**RE: T.J. HARDWARE (G16-D57A) DRAINAGE PLAN FOR BUILDING PERMIT
APPROVAL. ENGINEER'S STAMP DATE 1-22-96.**

**RE: T.J. HARDWARE (G16-D57A) DRAINAGE PLAN FOR BUILDING PERMIT
APPROVAL. ENGINEER'S STAMP DATE 11-22-95.**

**RE: T.J. HARDWARE (G16-D57A) DRAINAGE PLAN FOR BUILDING PERMIT
APPROVAL. ENGINEER'S STAMP DATE 10-23-95.**

**RE: T.J. HARDWARE (G16-D57A) DRAINAGE PLAN FOR FOUNDATION PERMIT
APPROVAL. ENGINEER'S STAMP DATE 10-12-95.**

REVISED 1/22/95
REVISED 1/22/95
REVISED 10/24/95
REVISED 10/23/95

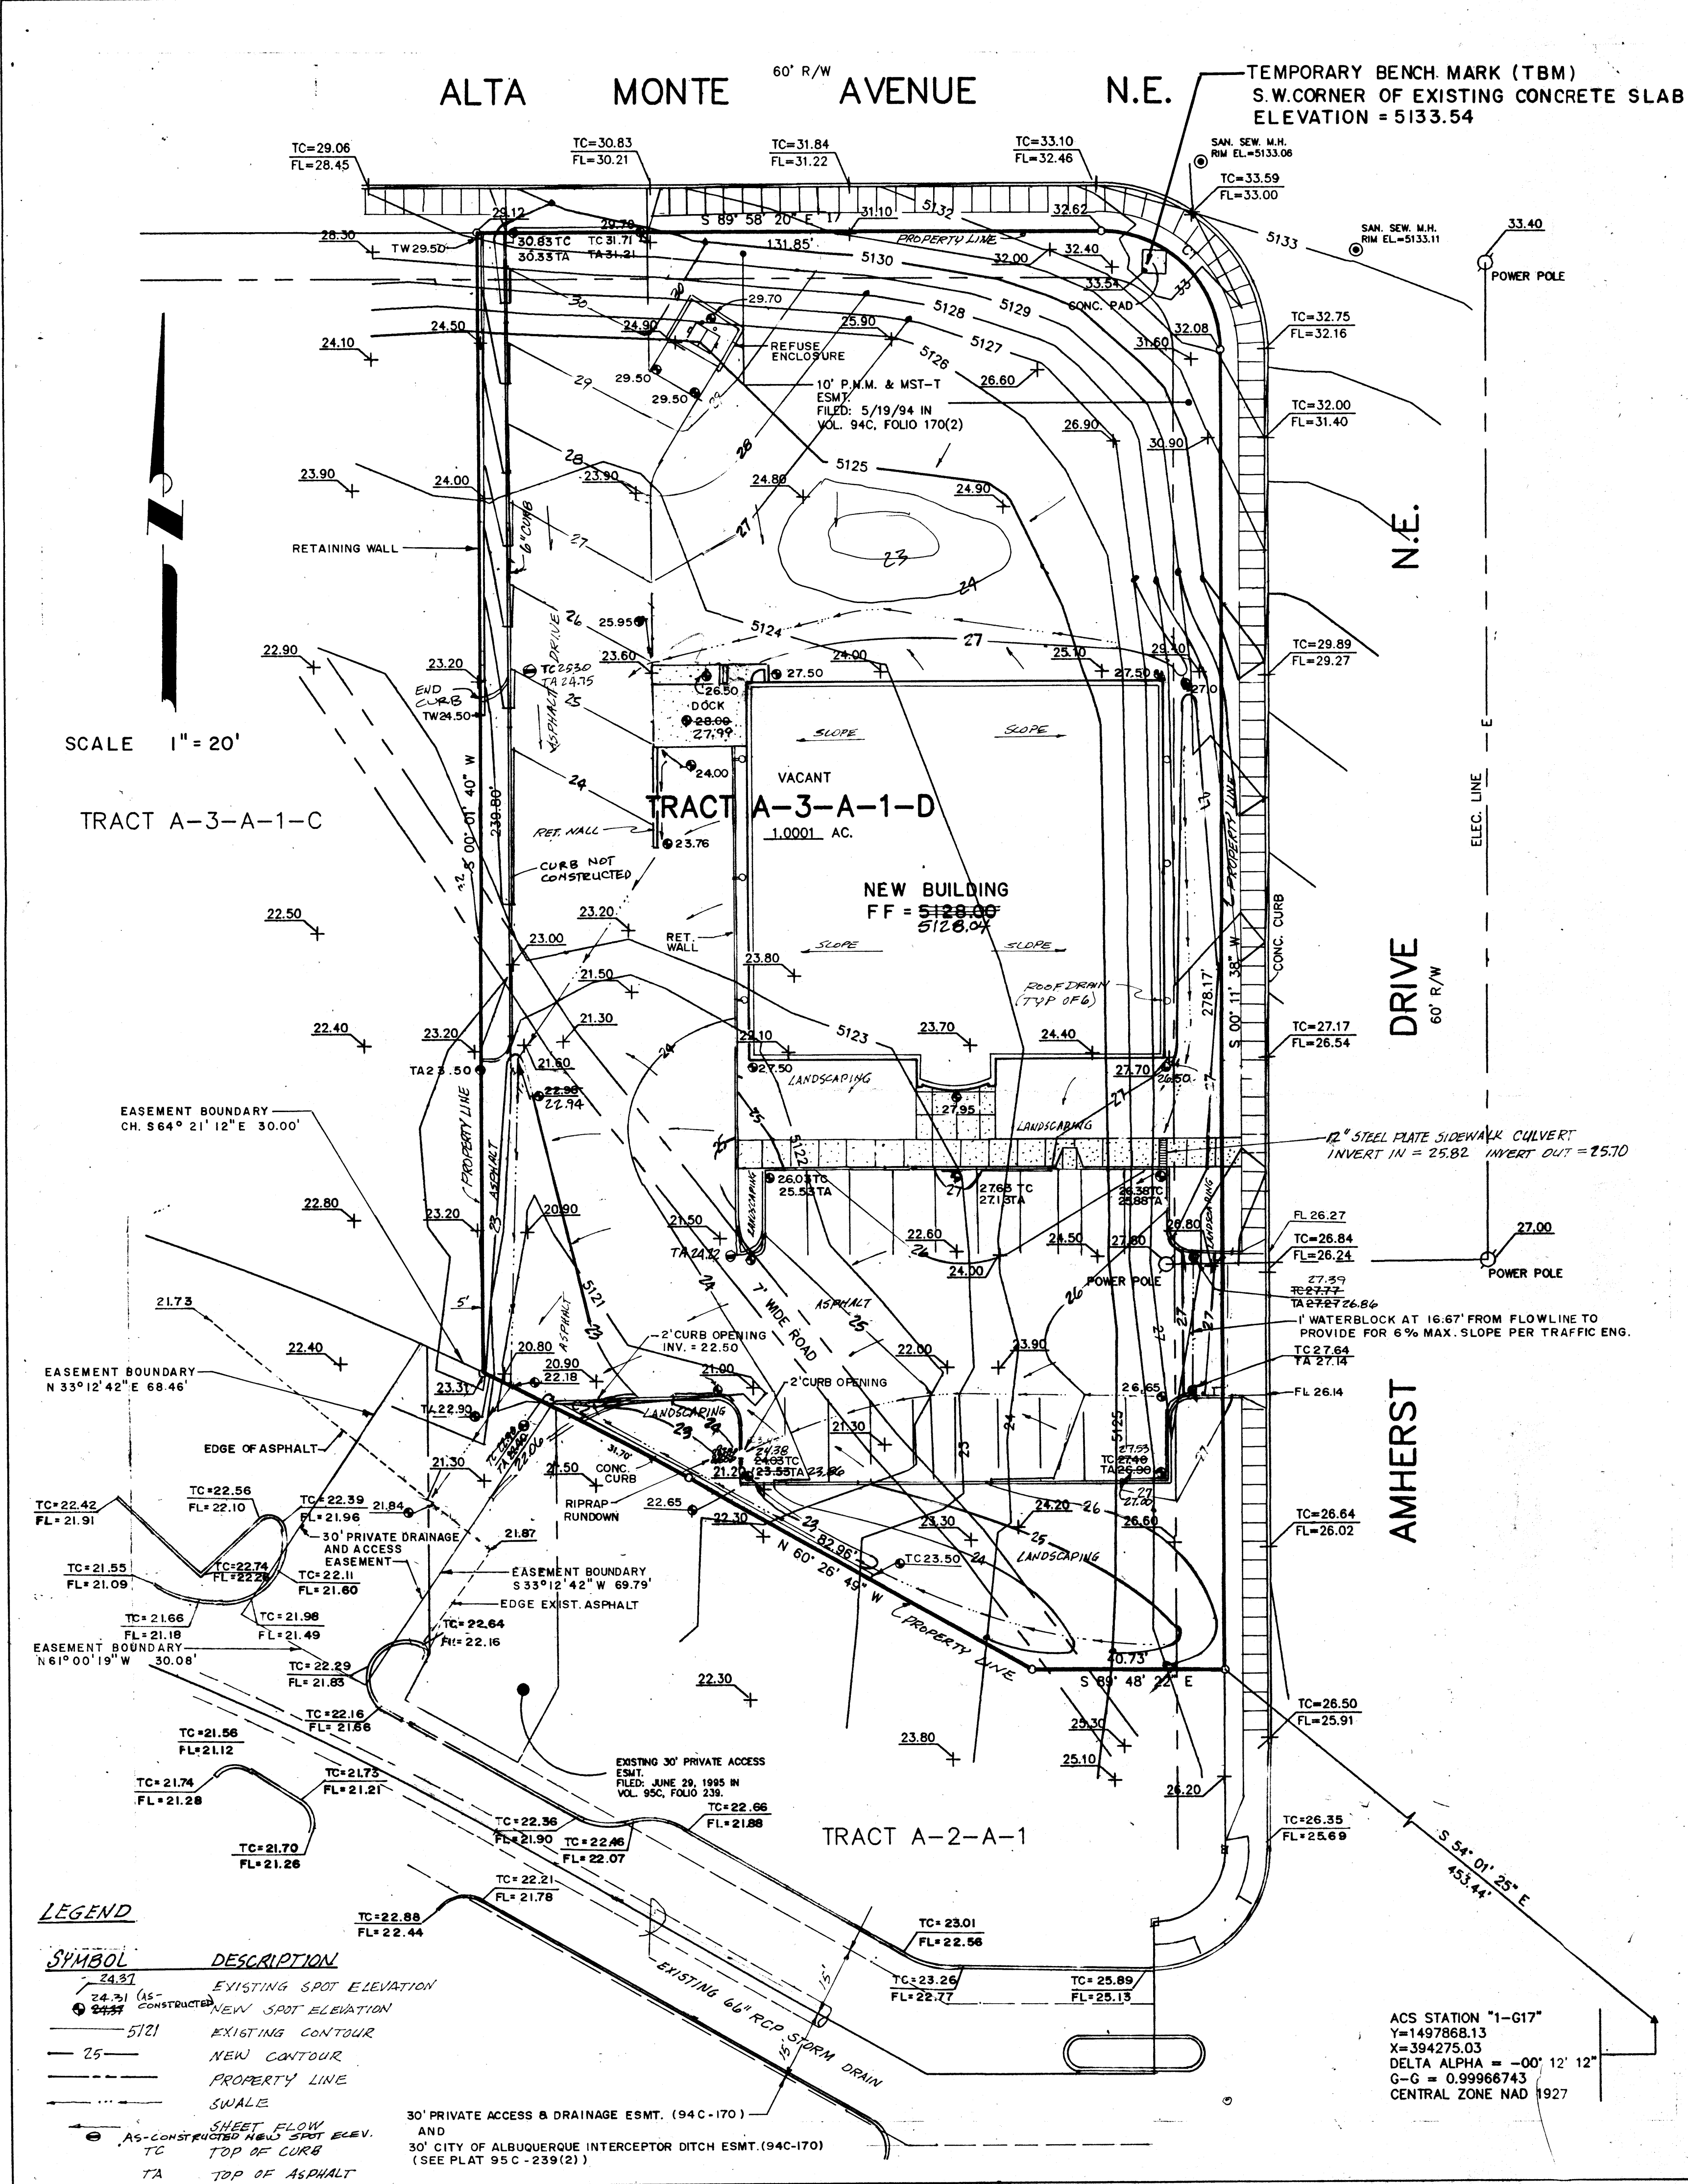
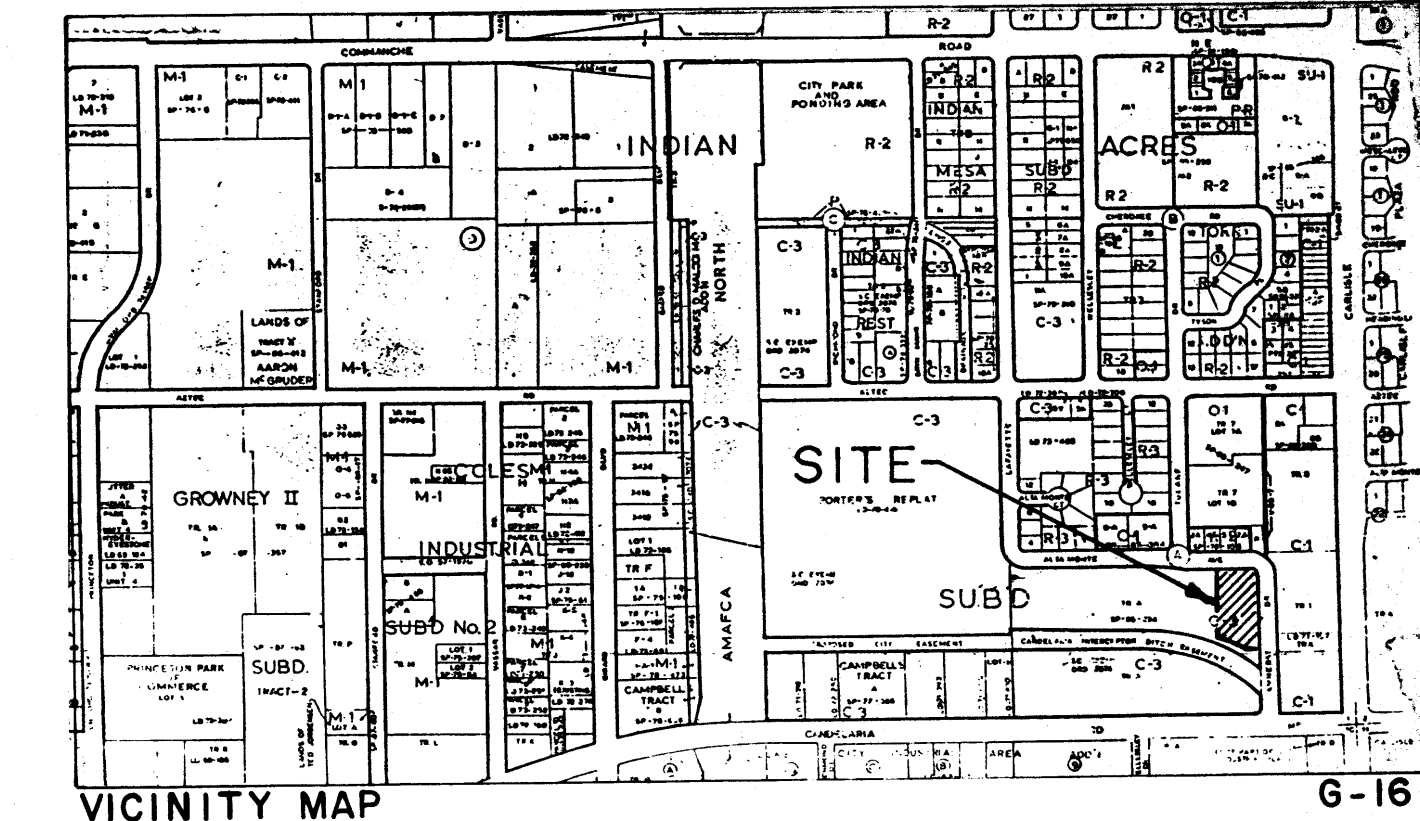
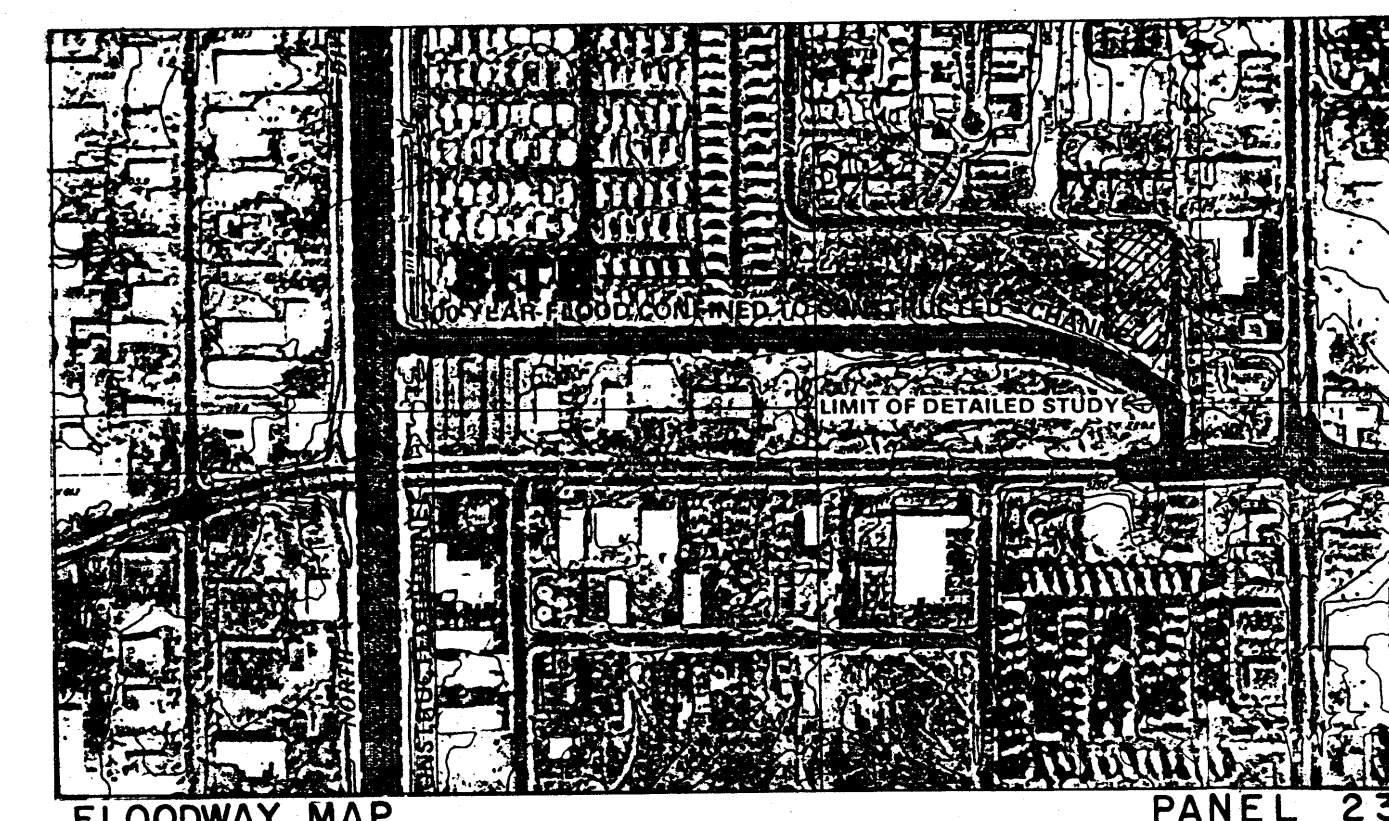
1. Please provide a copy of the document that created the
30 foot drainage easement located on adjacent property
to the south. The plat in our files shows a 30 foot
access easement only.

1. Because you are carrying flows through adjacent
property to the south, a drainage easement from the
property owner will be required.

1. Show the existing 66" storm drain line on your plan.
2. Because you are carrying flows through adjacent
property to the south, a drainage easement from the
property owner will be required.
